Subject: Land At Salt Box West Of Shripney Road Bognor Regis PO22 9NW - BE/168/21/DOC

Planning Application Reference: BE/168/21/DOC

Proposal: Approval of details reserved by condition imposed under BE/135/18/PL relating to Outline conditions 20-noise report, 21-renewable or low carbon energy sources & 22-external lighting & Full Planning conditions 12-surface water drainage systems, 13-discharge of flows to watercourses, 14-maintenance & management of surface water drainage system & 16-foul drainage system.

Condition 20 – Noise report

Plan View
Scale - 1 : 1000

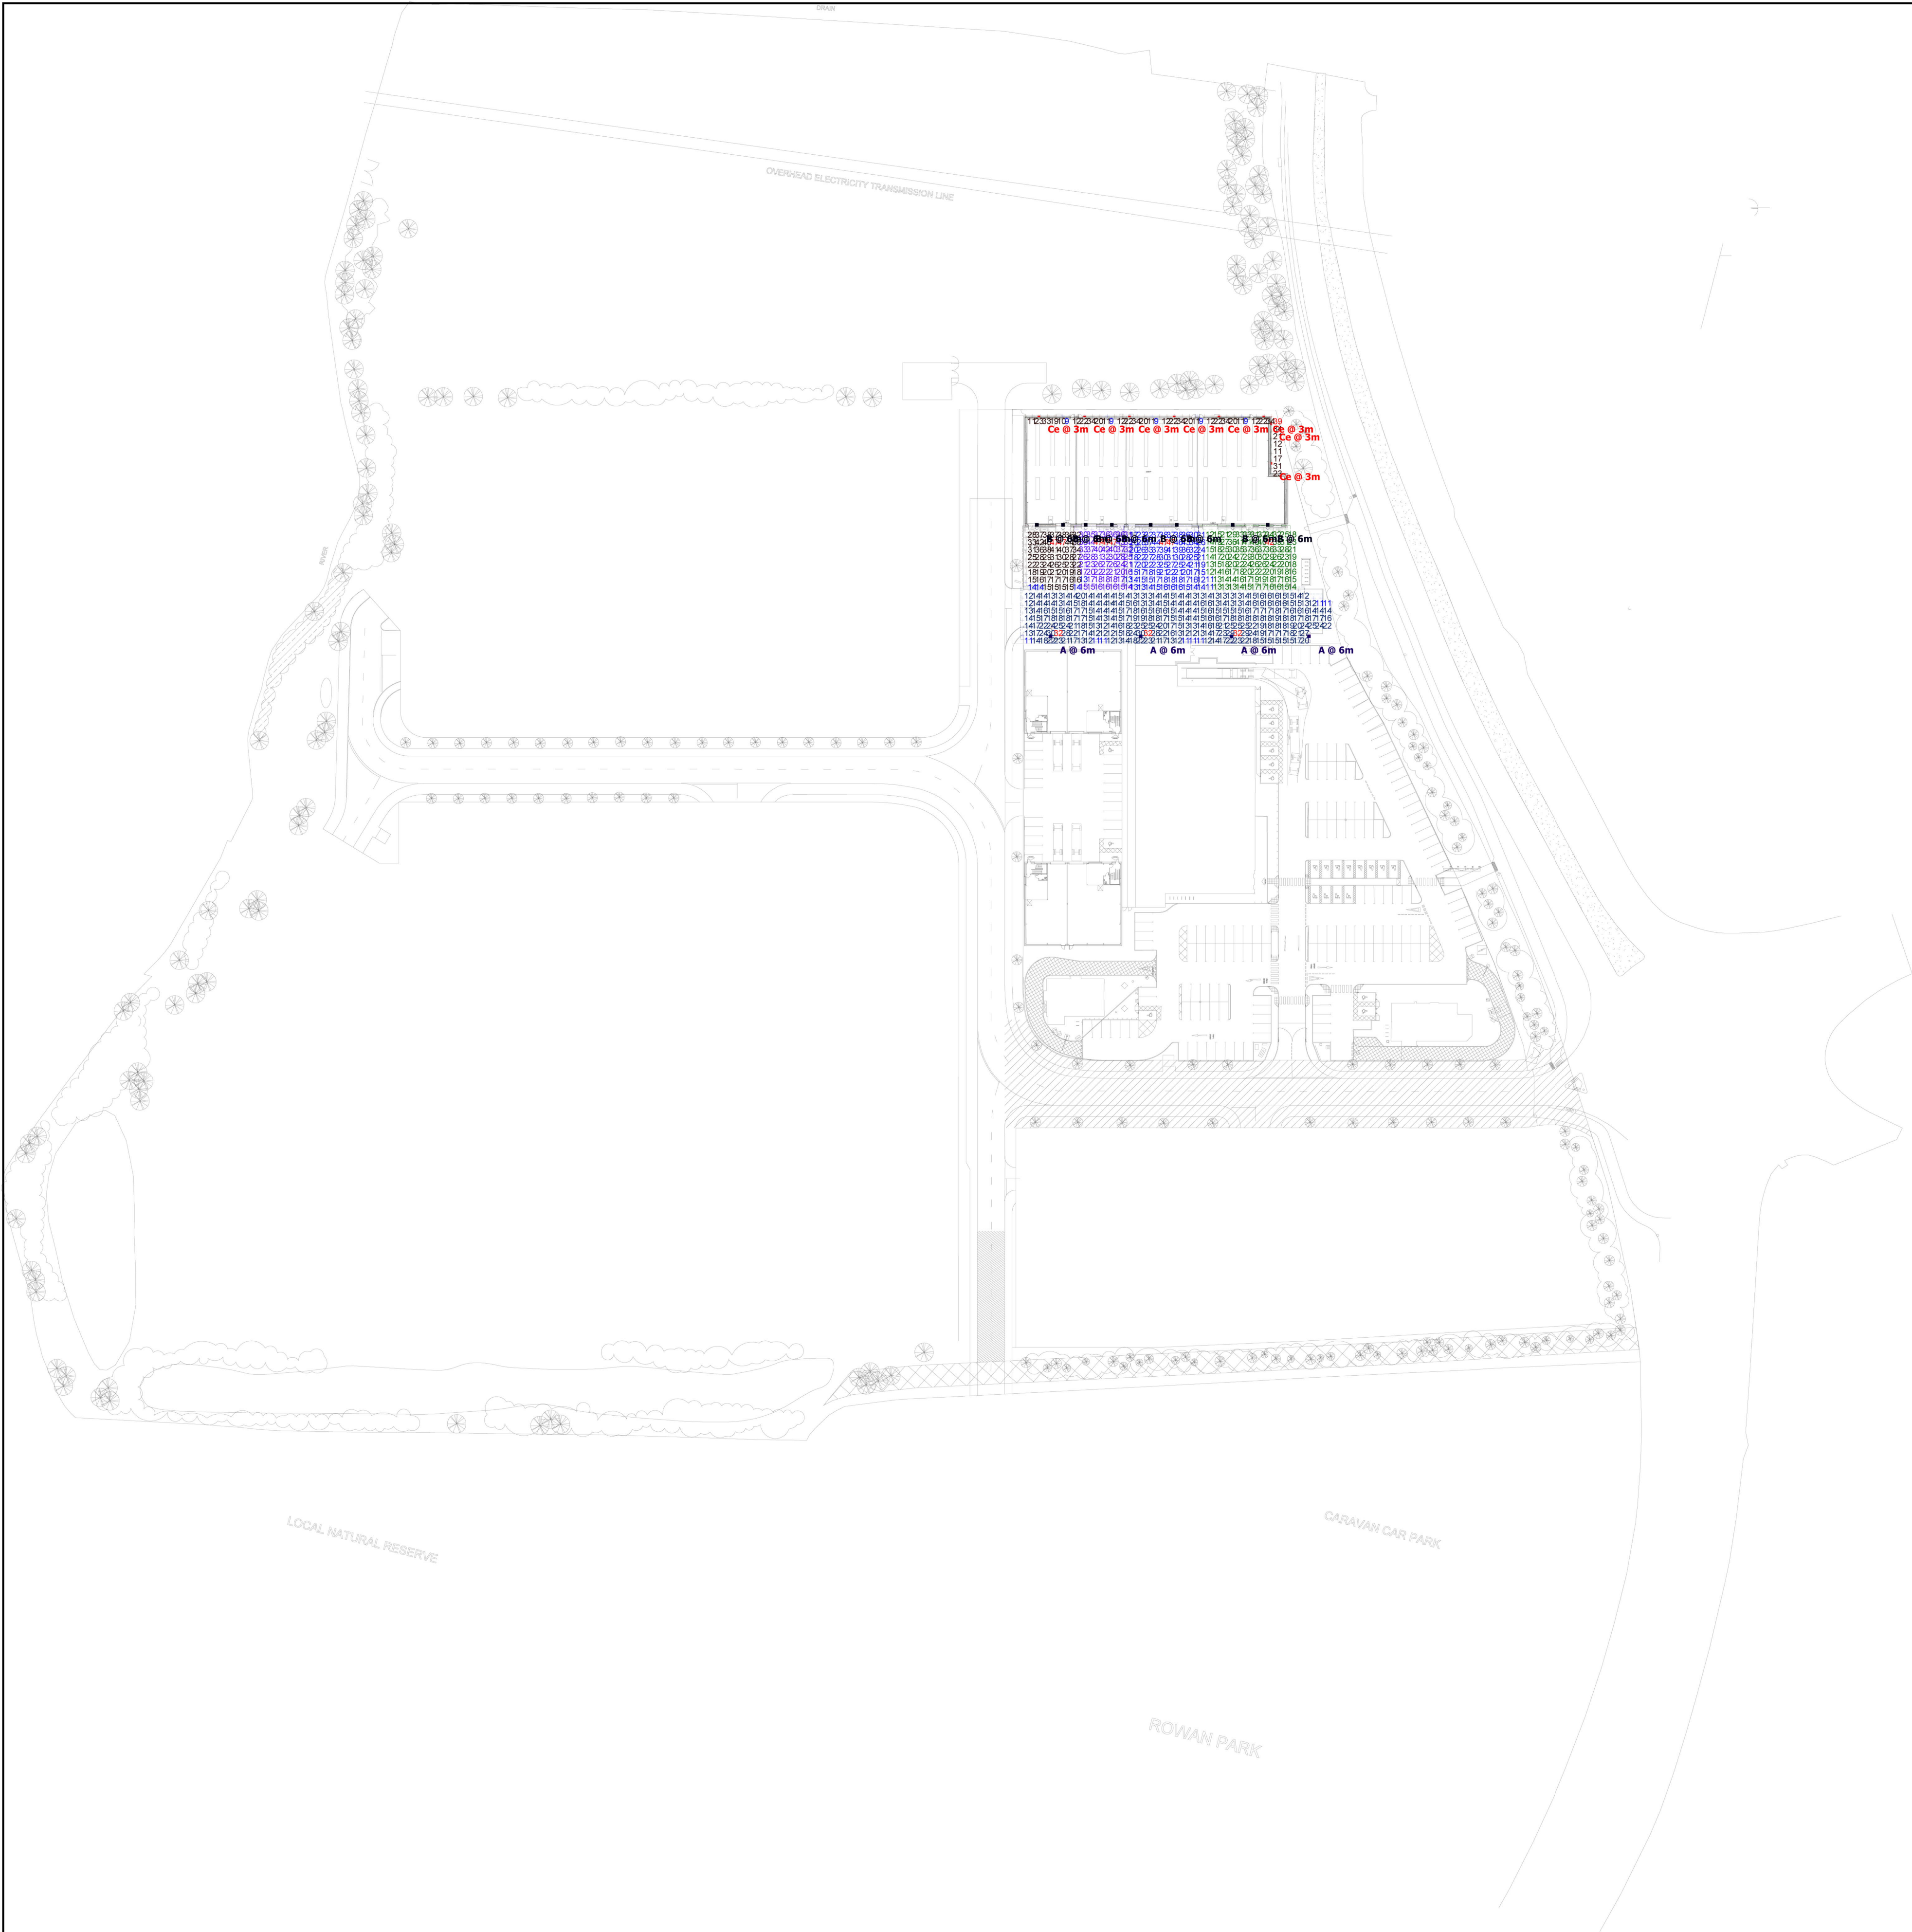
I note the proposed external lighting is Holophane D-series wall and single column, and Denver elite wall mounted. Having reviewed the catalogues I can confirm these lights incorporate design to minimise glare, spill and sky glow.

The following information is required to discharge the condition.

- a) Details of zone E2 lighting luminaires (lux levels)
- b) Timings of lighting
